**WELWYN HATFIELD BOROUGH COUNCIL
ASSISTANT DIRECTOR (PLANNING)**

DELEGATED APPLICATION

Application No: 6/2022/2773/HOUSE
Location: 16 Nimrod Drive Hatfield AL10 9LS
Proposal: Erection of two storey rear extension
Officer: Ms Ashley Ransome

○ SIDE ELEVATION 1, PROPOSED
SCALE 1:100

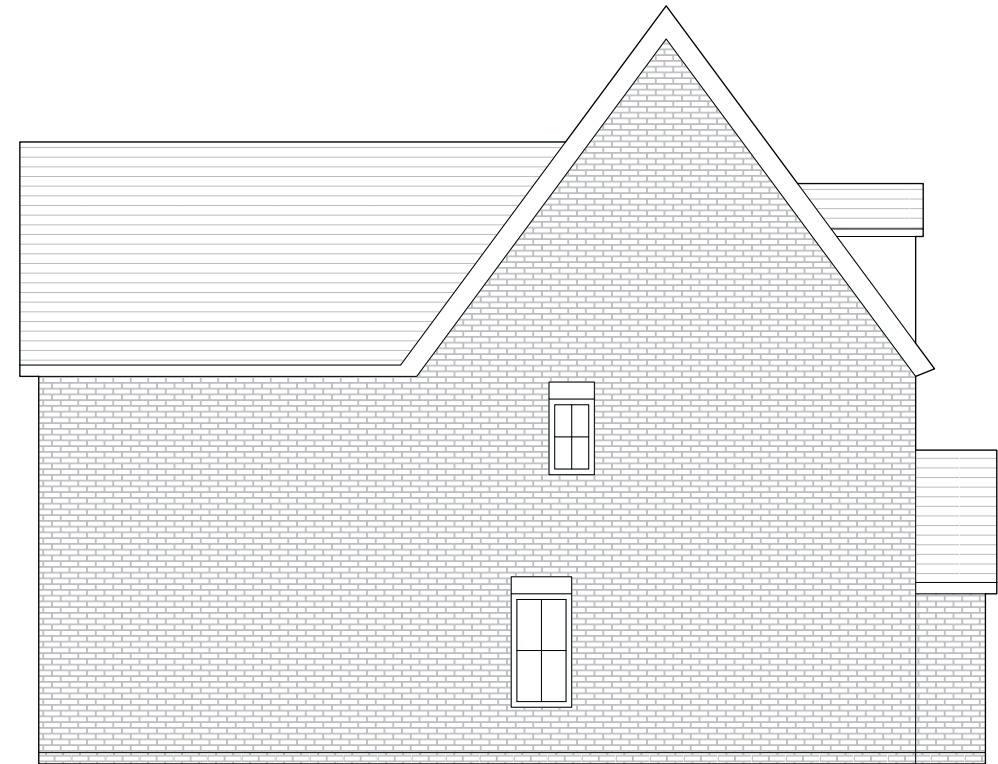
The windows proposed to be inserted into the flank elevation of the application dwelling are not considered to pose a significant impact to the privacy of the occupants at No.14 since these windows are proposed to be obscure glazed. A condition to this effect will be imposed.

1. Any upper floor window located in a wall or roof slope forming a side elevation of the dwelling must be obscure-glazed to a level equivalent to Pilkington Level 3 or above and non-opening unless the parts of the window which can be opened are more than 1.7 metres above the floor of the room in which the window is installed, and shall be retained in that form thereafter. Obscure glazing does not include applied film or one-way glass.

○ FIRST FLOOR PLAN, PROPOSED
SCALE 1:100

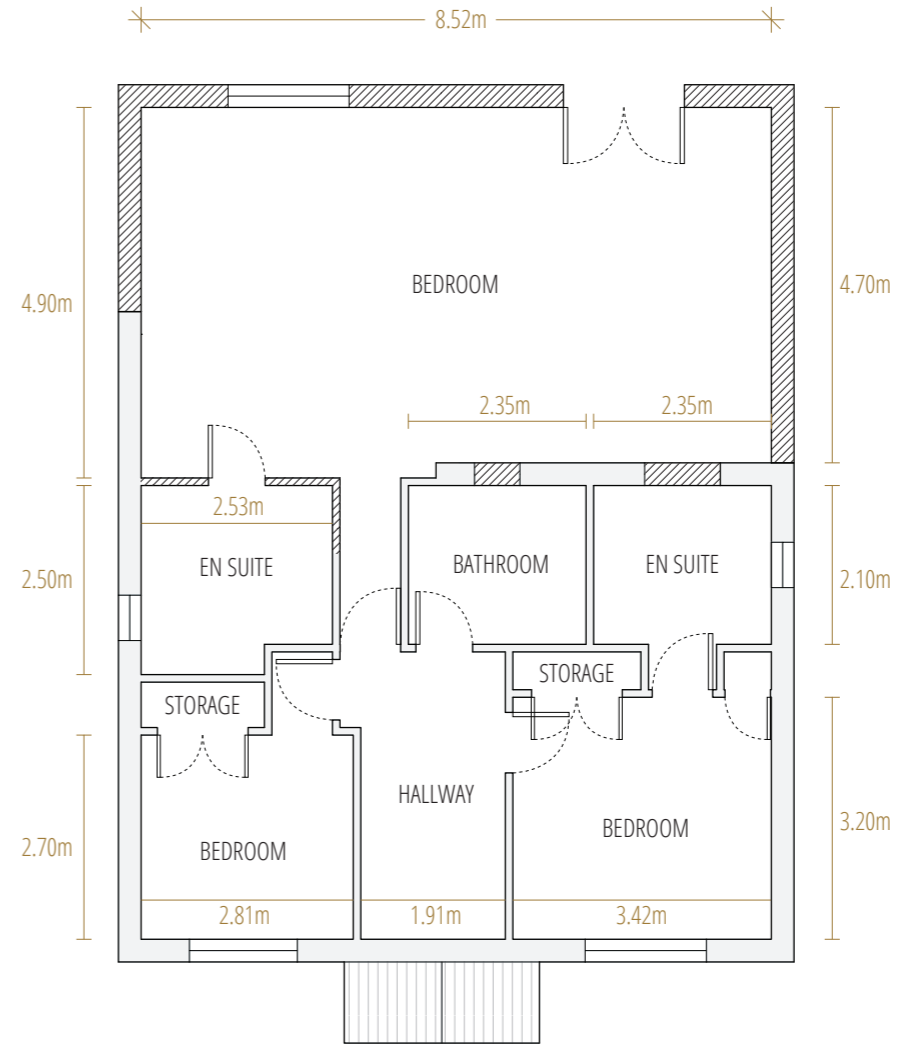
It is noted that Hatfield Town Council raised a concern with regards to the first-floor extension creating one very large room. Whilst the size of the room is large, relative to other rooms in the host dwelling, no harm or policy conflict has been identified which would justify a refusal of planning permission on this basis.

Whilst it is acknowledged that the proposed first floor extension would extend beyond the neighbouring property at No.14 creating further bulk at this level, it is considered that the size, scale, siting and design of the proposed development would have minimal impact on the residential amenity of the surrounding neighbouring properties. This is due to the orientation of the plots, whereby No.16 is sited to the north of the neighbouring dwelling at No.14, thus the path of the sun would not be significantly impacted as a result of the proposal. Moreover, the proposed extension is sited away from the boundary, with the neighbouring property at No.14 sited further back into the site than that of the application dwelling, so much so that the proposed extension would not significantly extend beyond the rear elevation of No.14.
